Scheme 6: A66 Dualling project Appleby – Brough section

Reply to NH response, Examination Library Reference REP1-087

Drawing Title
Land Plans
Regulation 5(2)(i)
Sheet 5 of 6

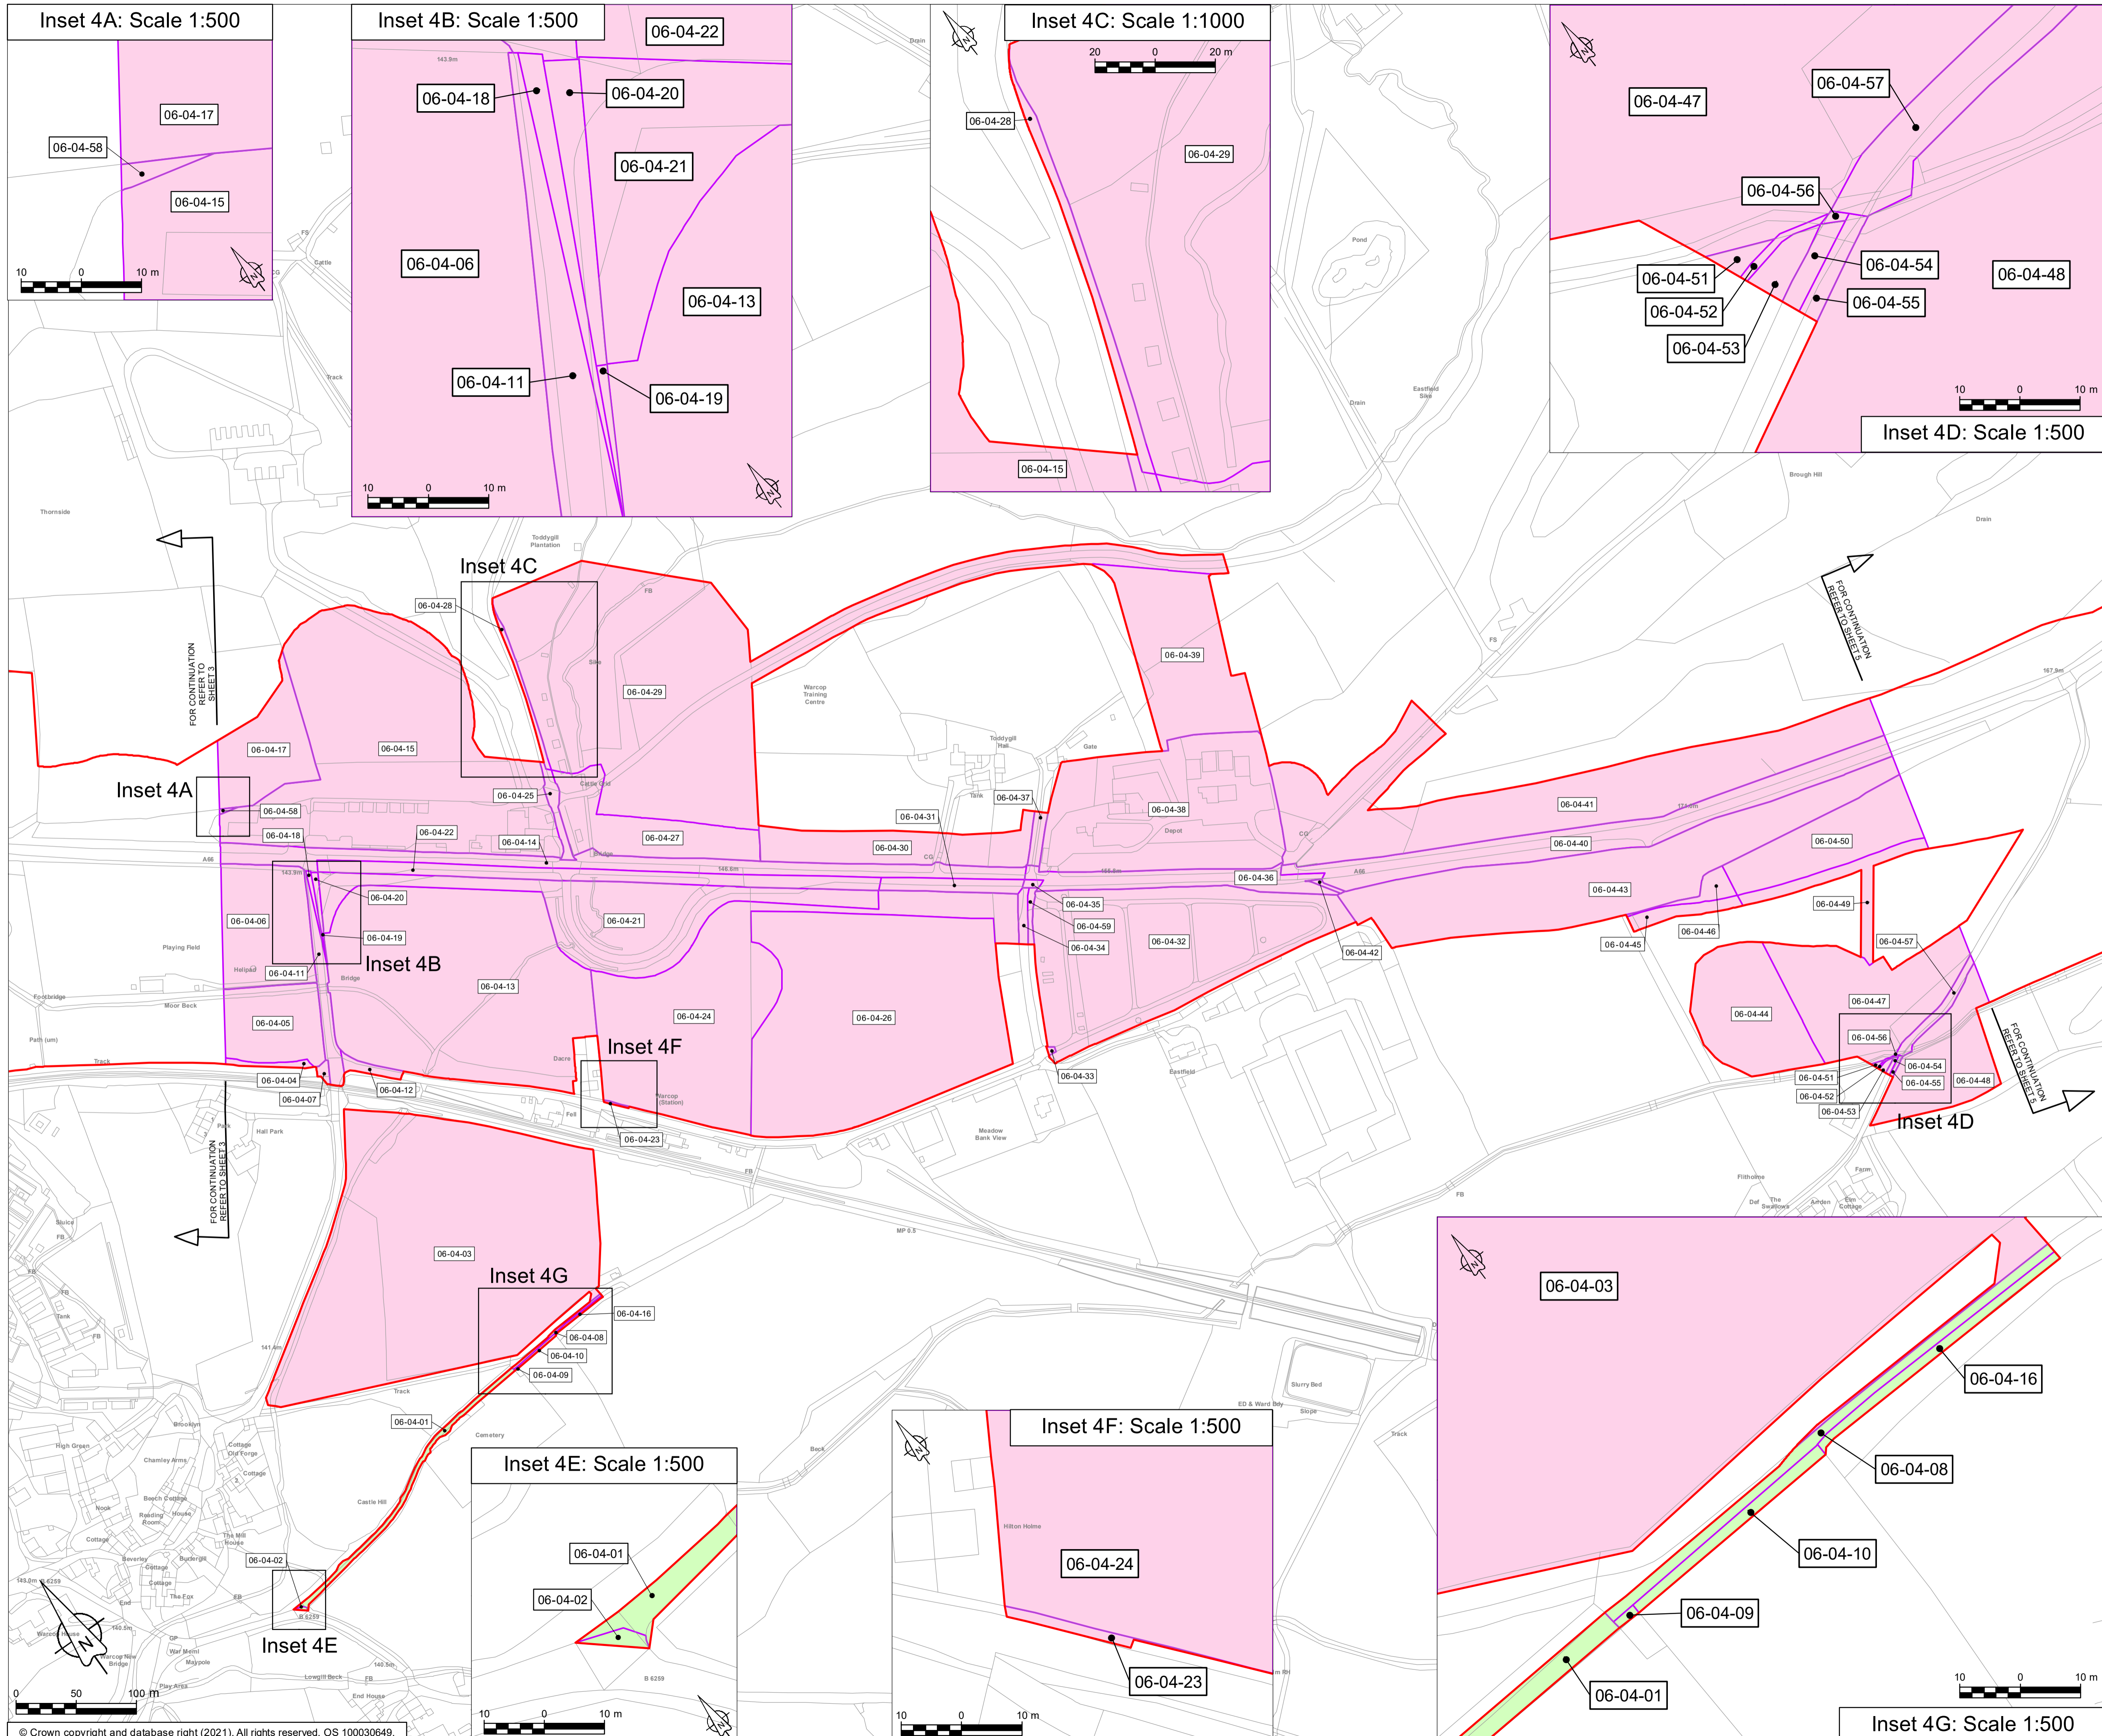
However, I am not convinced that adequate consideration has been given to the merits of moving the suggested alignment of the new A66 northwards in the eastern section of scheme 6 in the area covered by Sheets 4 & 5 of the General Arrangements Drawings (APP-014). This is not to suggest a 'northern route' taking a wide sweep into the AONB, but to ask again for a look at continuing the incursion into the AONB from the areas covered by Sheet 4 continuing into the area covered by Sheet 5. Also to ask why in the area covered by Sheet 4 the new A66 has not utilised the 'old' A66 for the northern carriageway so that what is now shown as the new A66 southern carriageway is not utilised as the new 'B' road giving local access, which could then be continued into the area of Sheet 5, thus simplifying several access arrangements.

Drawing Title
Land Plans
Regulation 5(2)(i)
Sheet 4 of 6

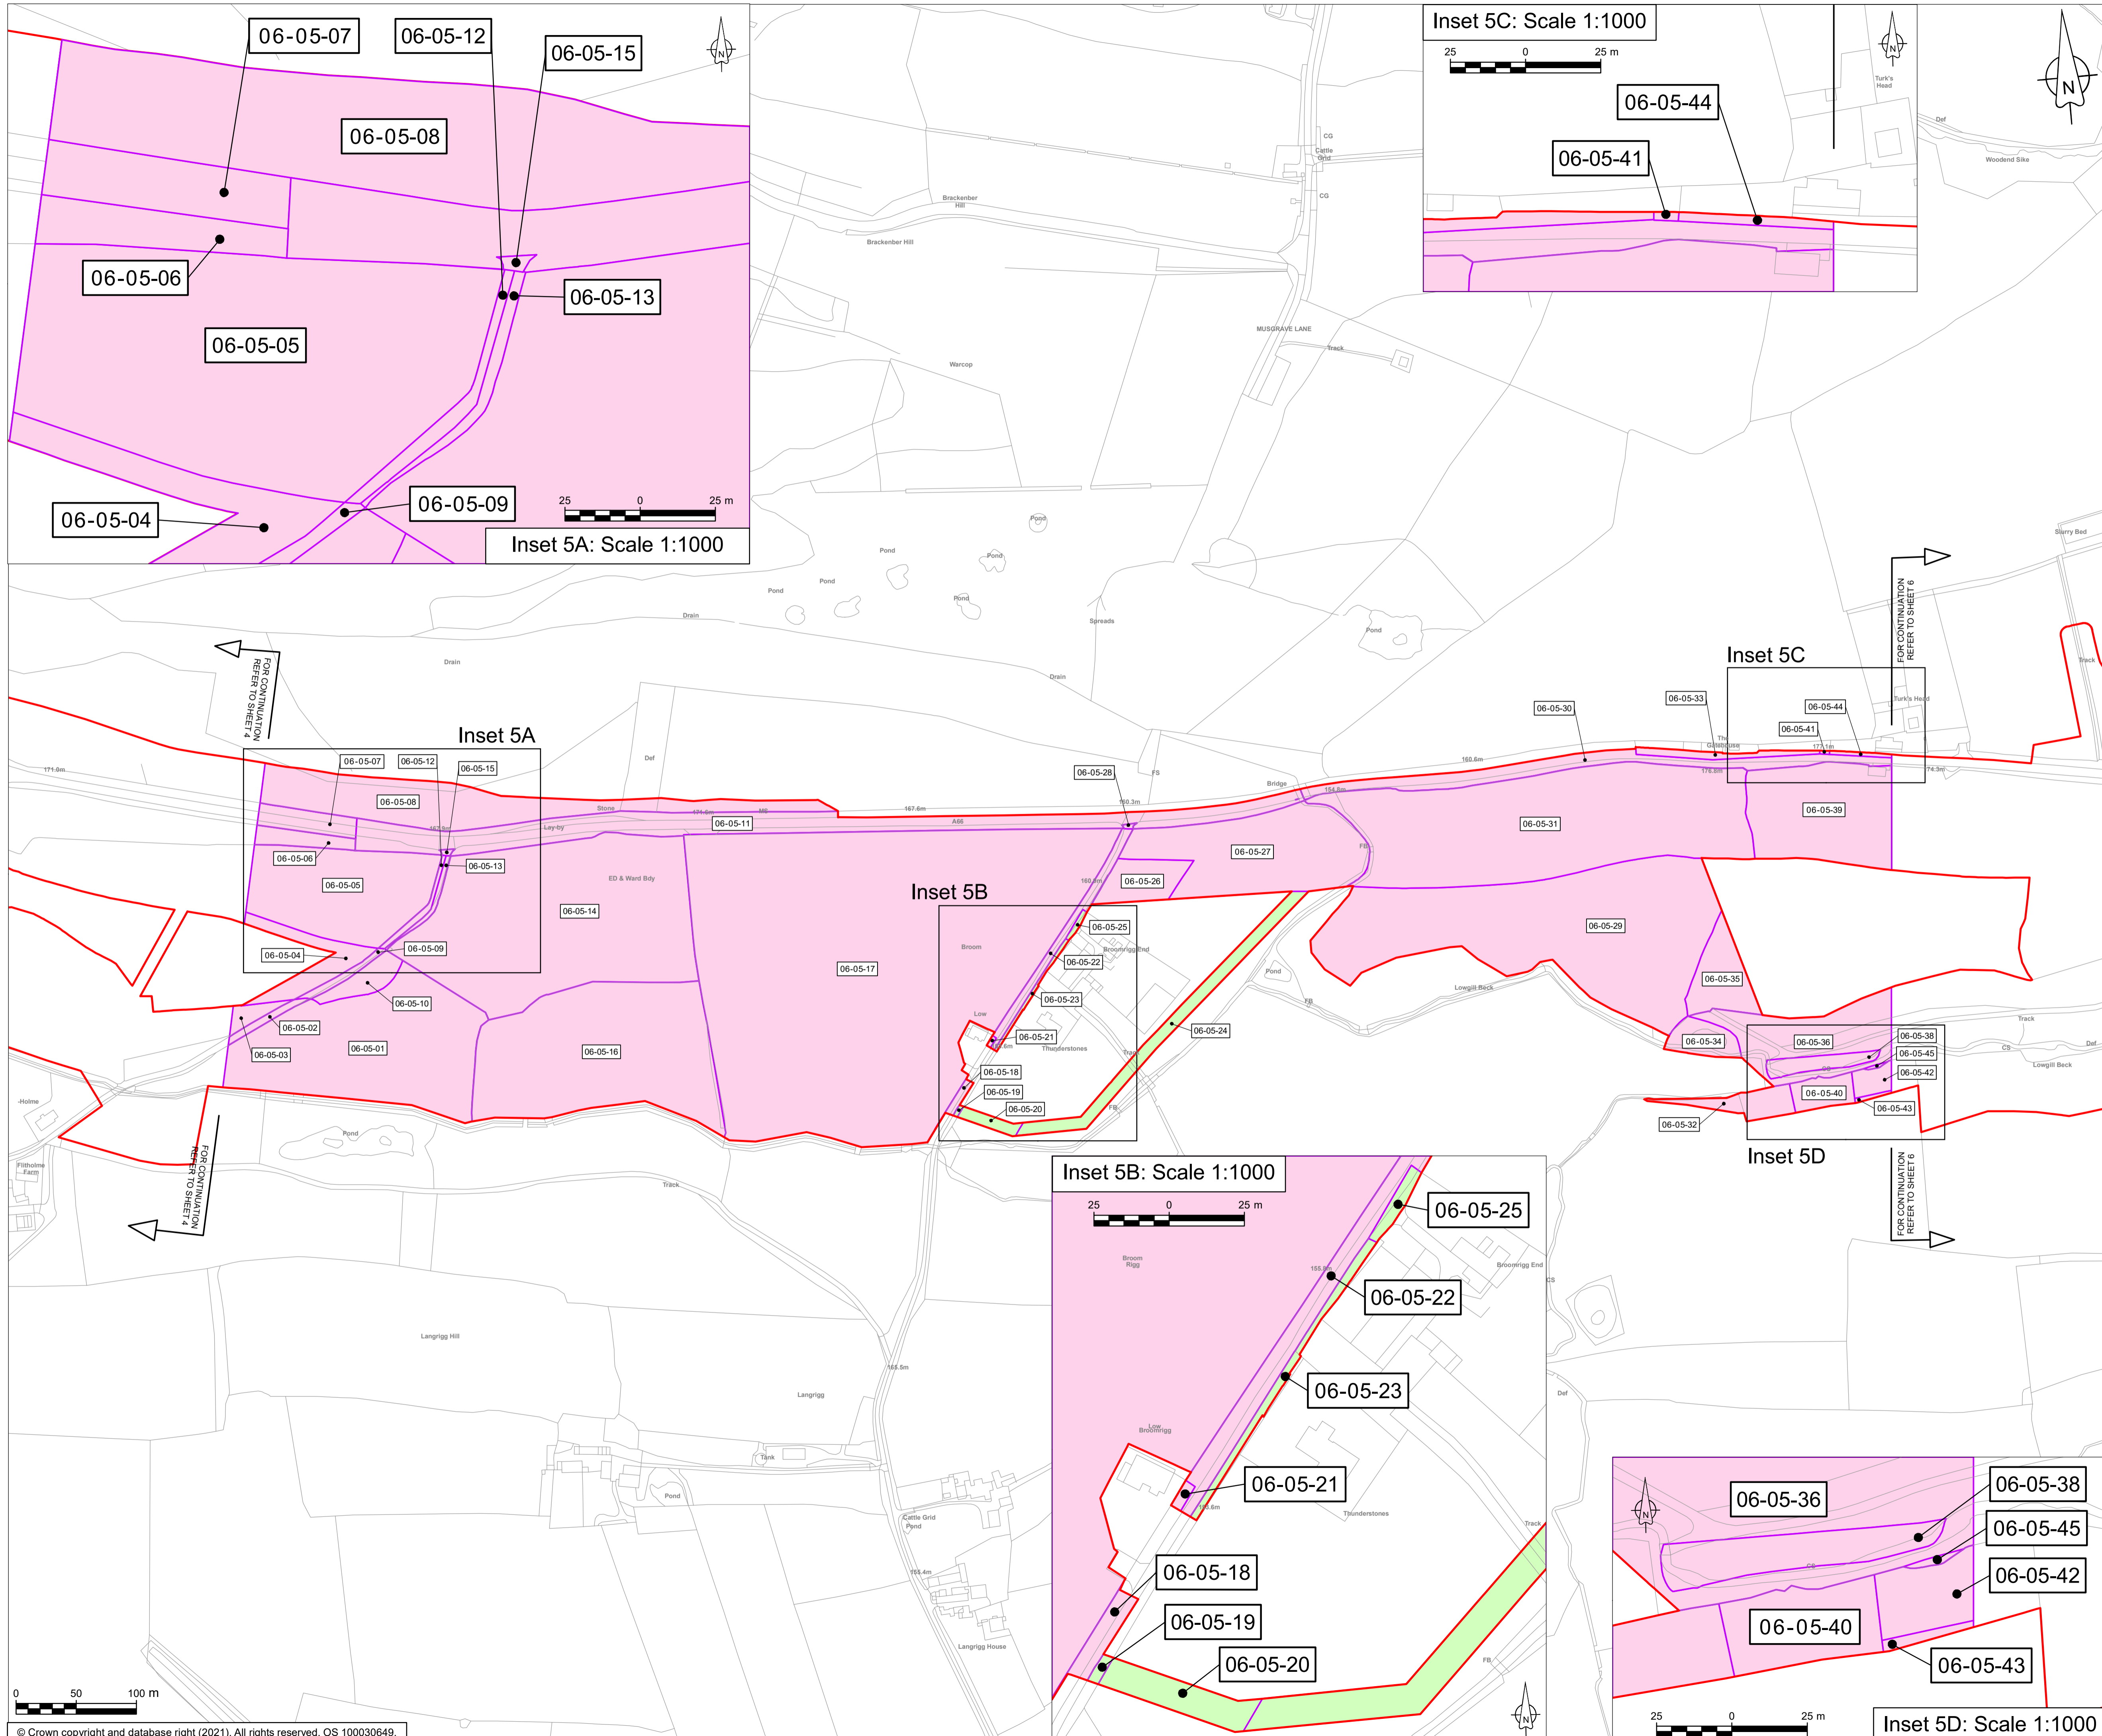
The current scheme requires the old A66 to be rebuilt in one section in the area covered by Sheet 4, and for a narrow strip of the AONB to be utilised for this, so why has this not been continued? All the reasons given for the incursion into the AONB and for the need to discuss land acquisition with DIO are equally valid as the road continues eastward towards Brough, especially as there is far less MOD infrastructure in this next section. In addition, if the engineering maps are consulted (APP-329, sheet 5 of 15, sheet 6 of 15) it can be seen that the variations in gradient and the embankments/ cutting required are significant; it is possible that the land immediately to the north of the old A66 in the eastern section offers a simpler option.
